Application for a Non-Material Amendment Following a Grant of Planning Permission

Demolition of existing store, shed and garage; construction of two storey side extension; erection of detached garage and loft extension with accommodation in the roofspace served by front/rear dormer windows and front rooflight, relocation of entrance door, front porch canopy, rear juliet balconies, alterations to fenestrations detail including replacement of doors and windows, internal alterations with associated front/rear landscaping works including alterations and extension to driveway.

23/1401/FUL

Blocking up small window in the Kitchen

Proposal
proposed elevations

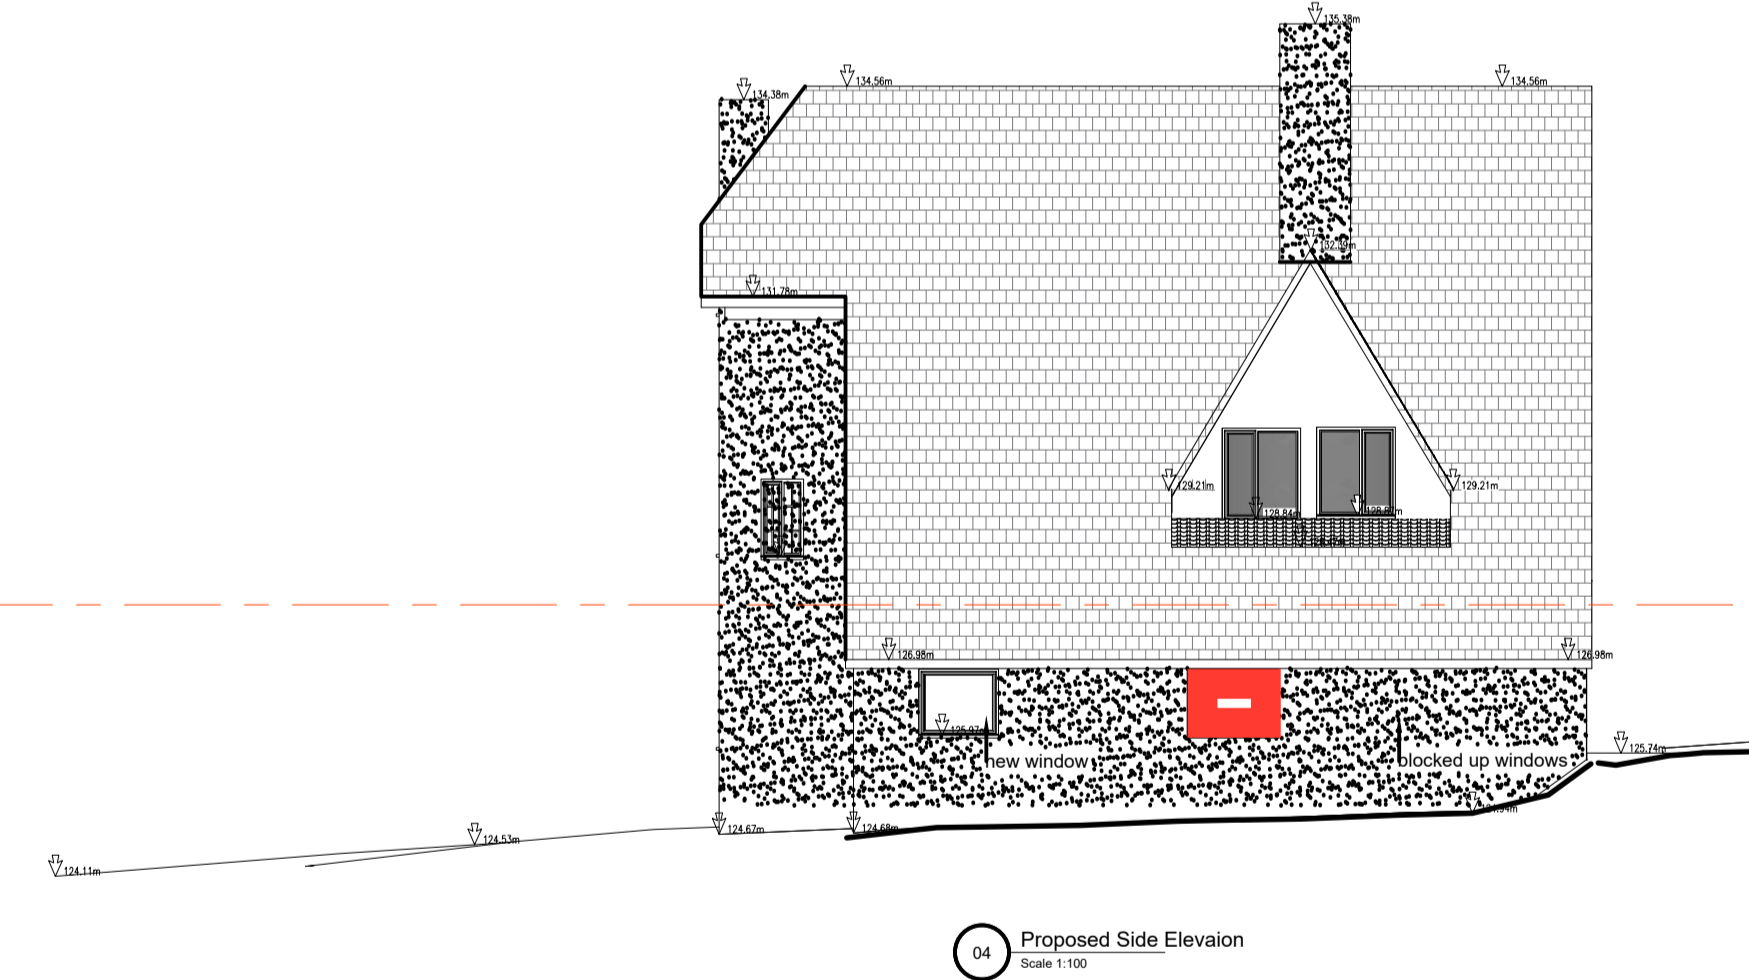
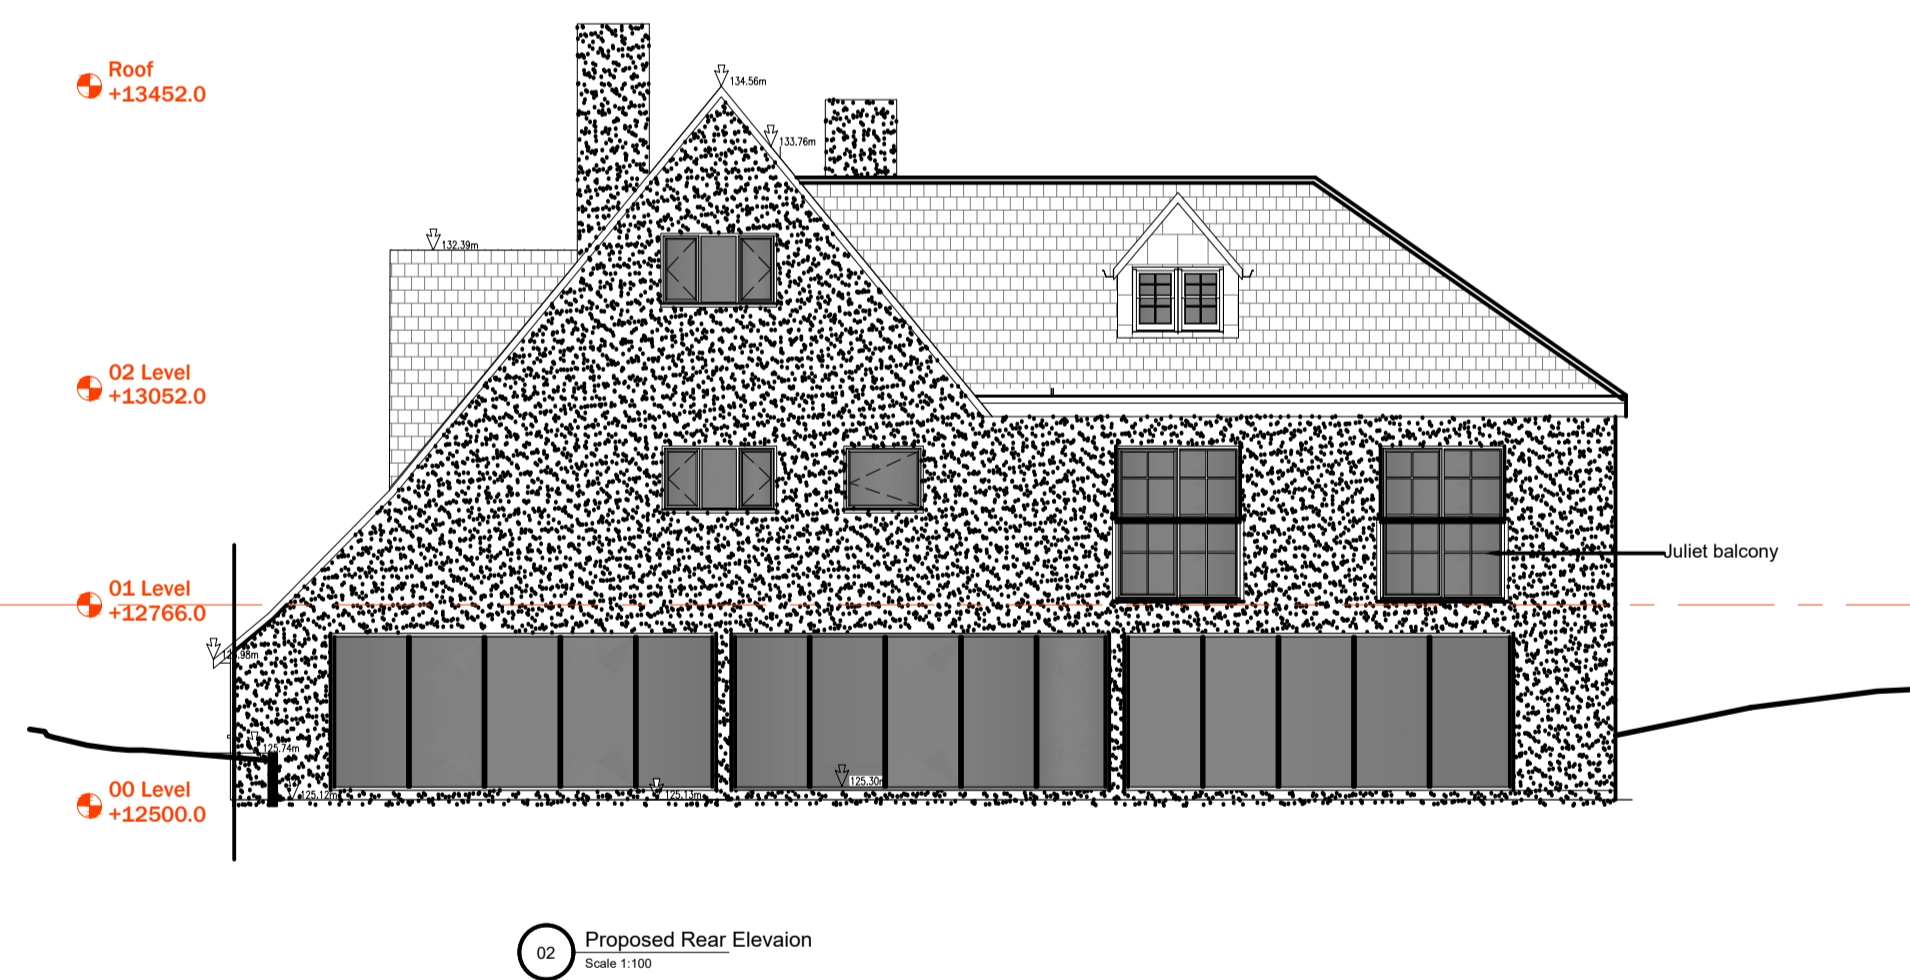
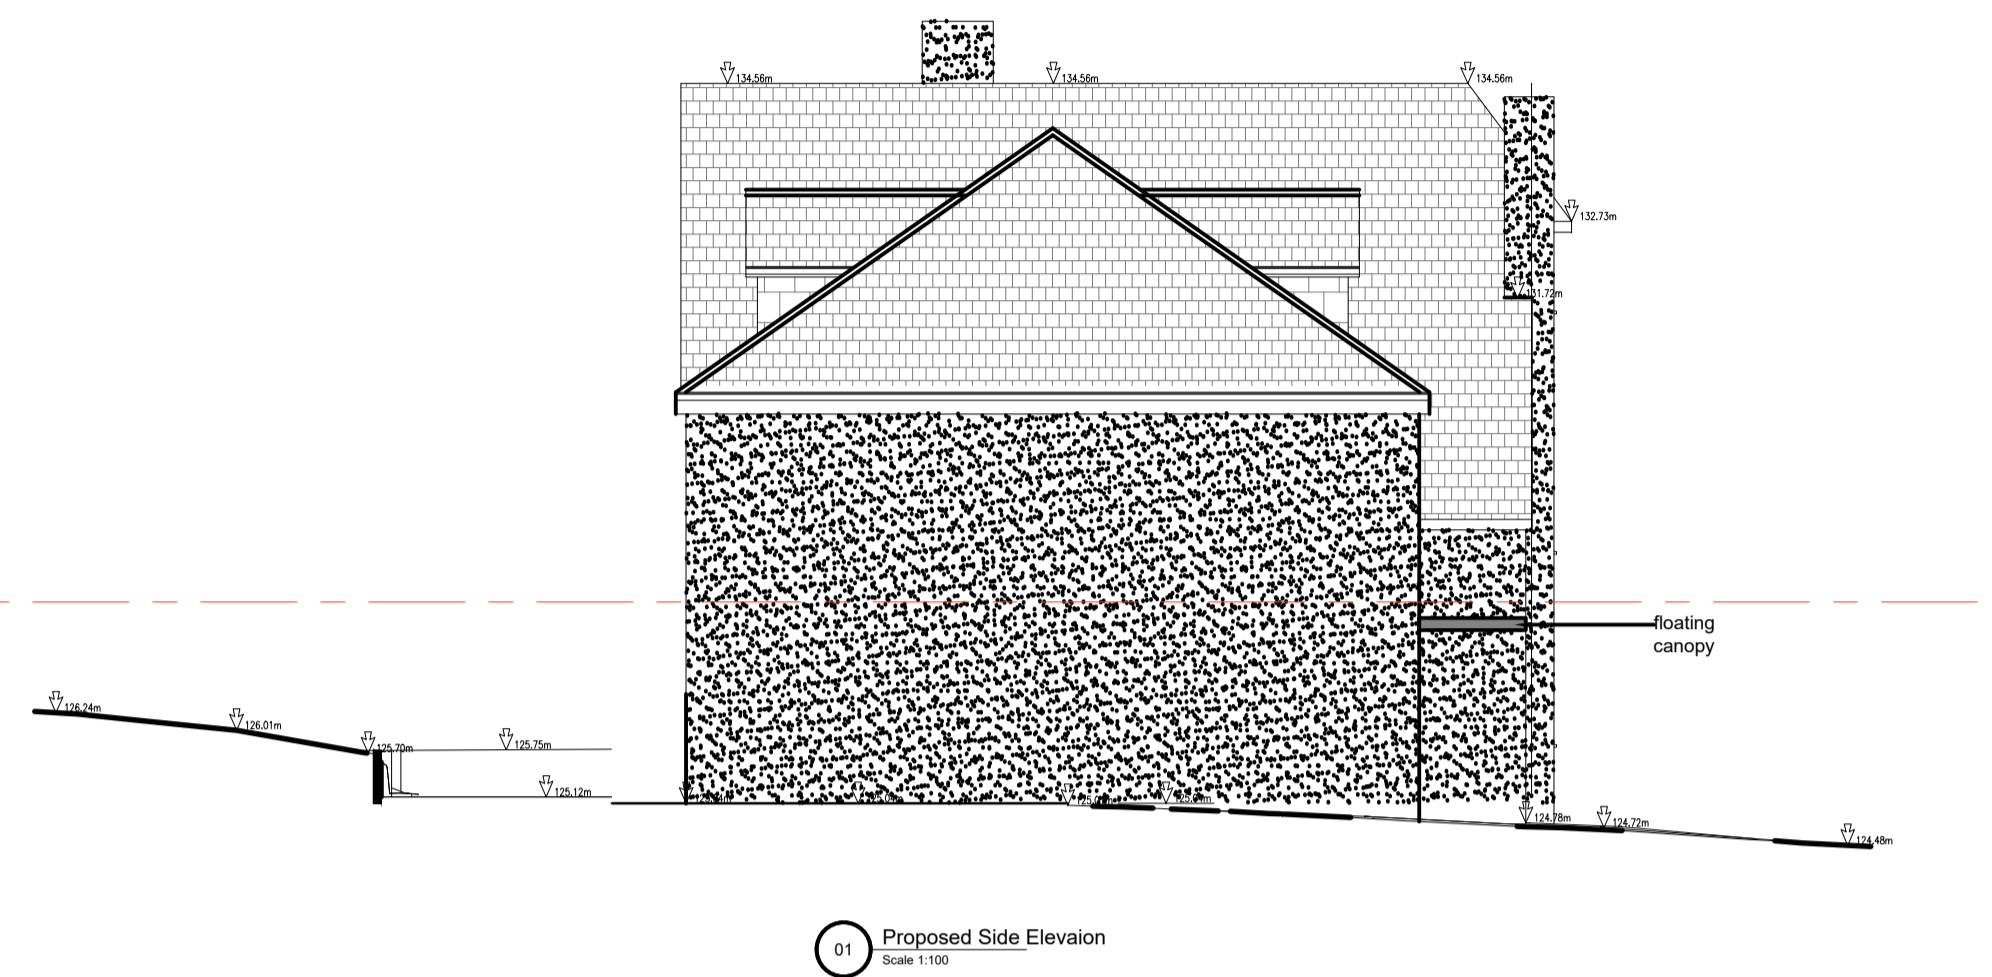
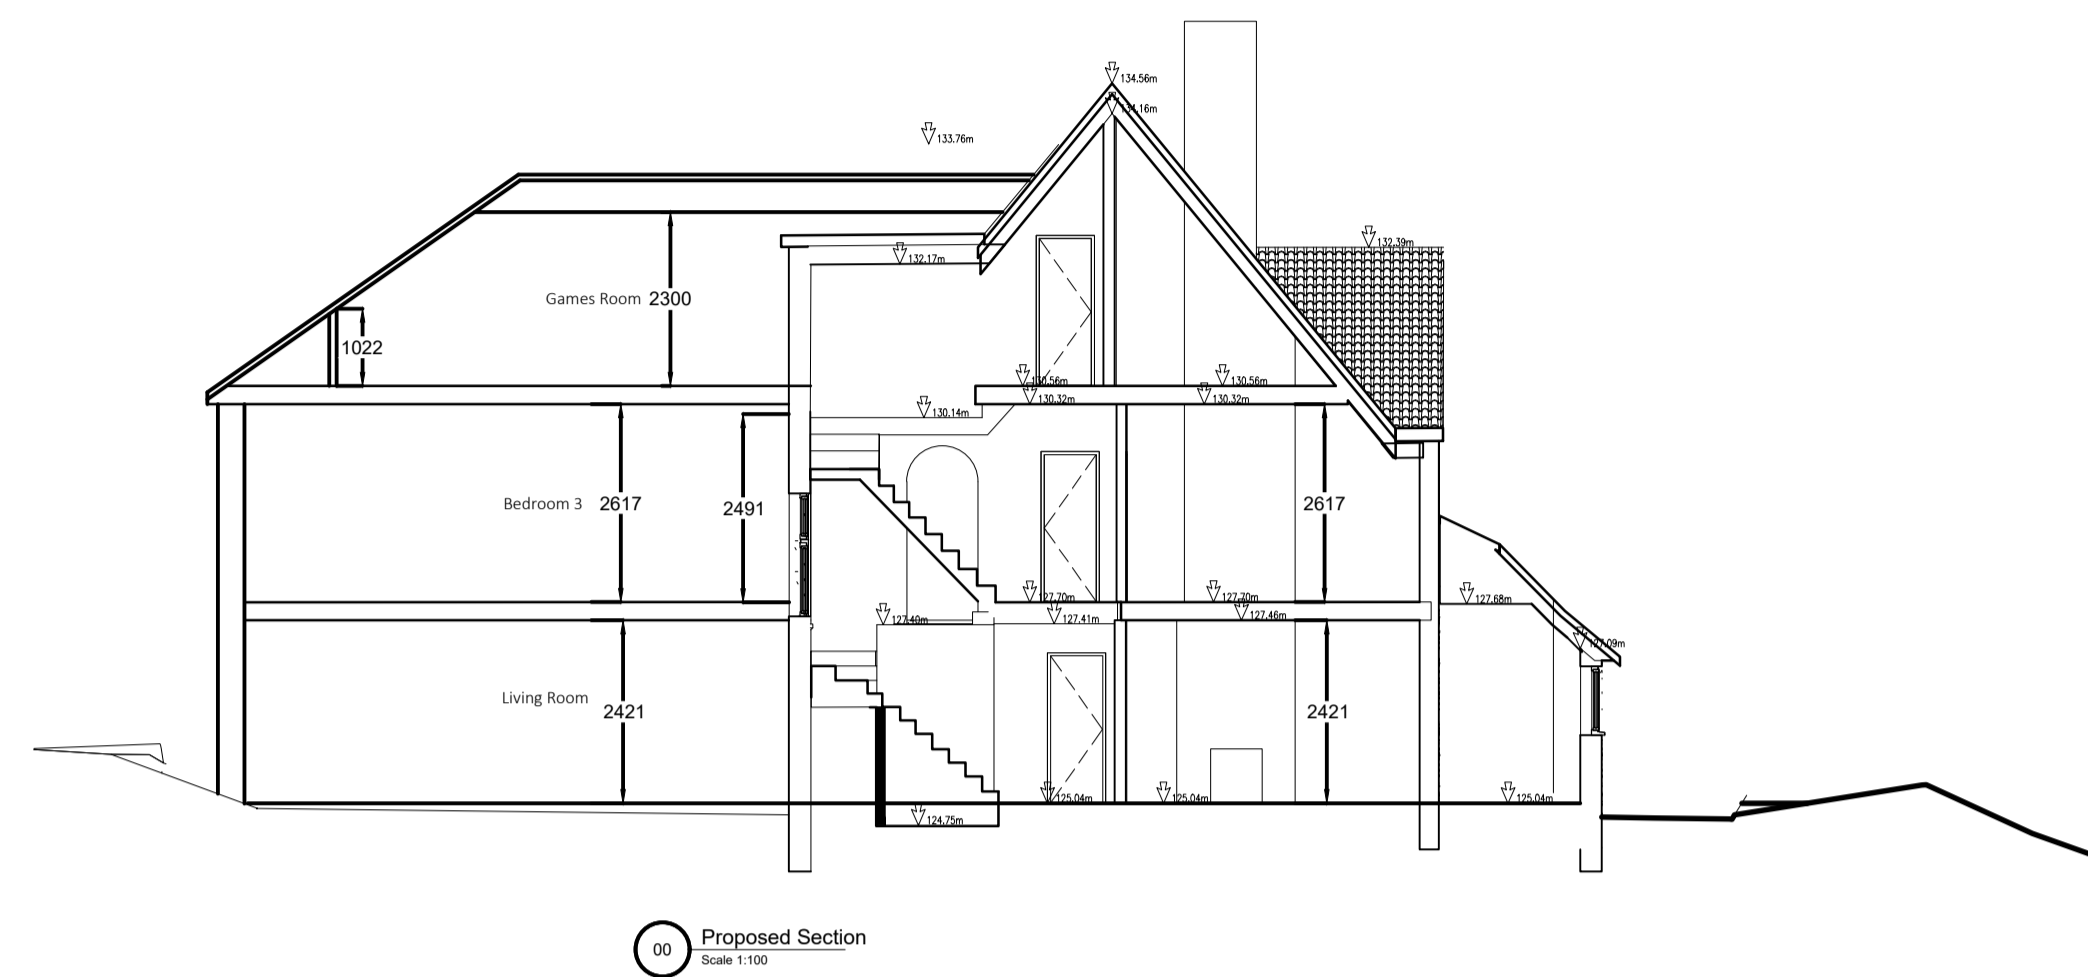
To allow for a better kitchen layout. The kitchen already benefits from a 5m wide floor to ceiling sliding doors to garden so there is plenty of light.

The window looks out onto next door neighbours fence and garden.
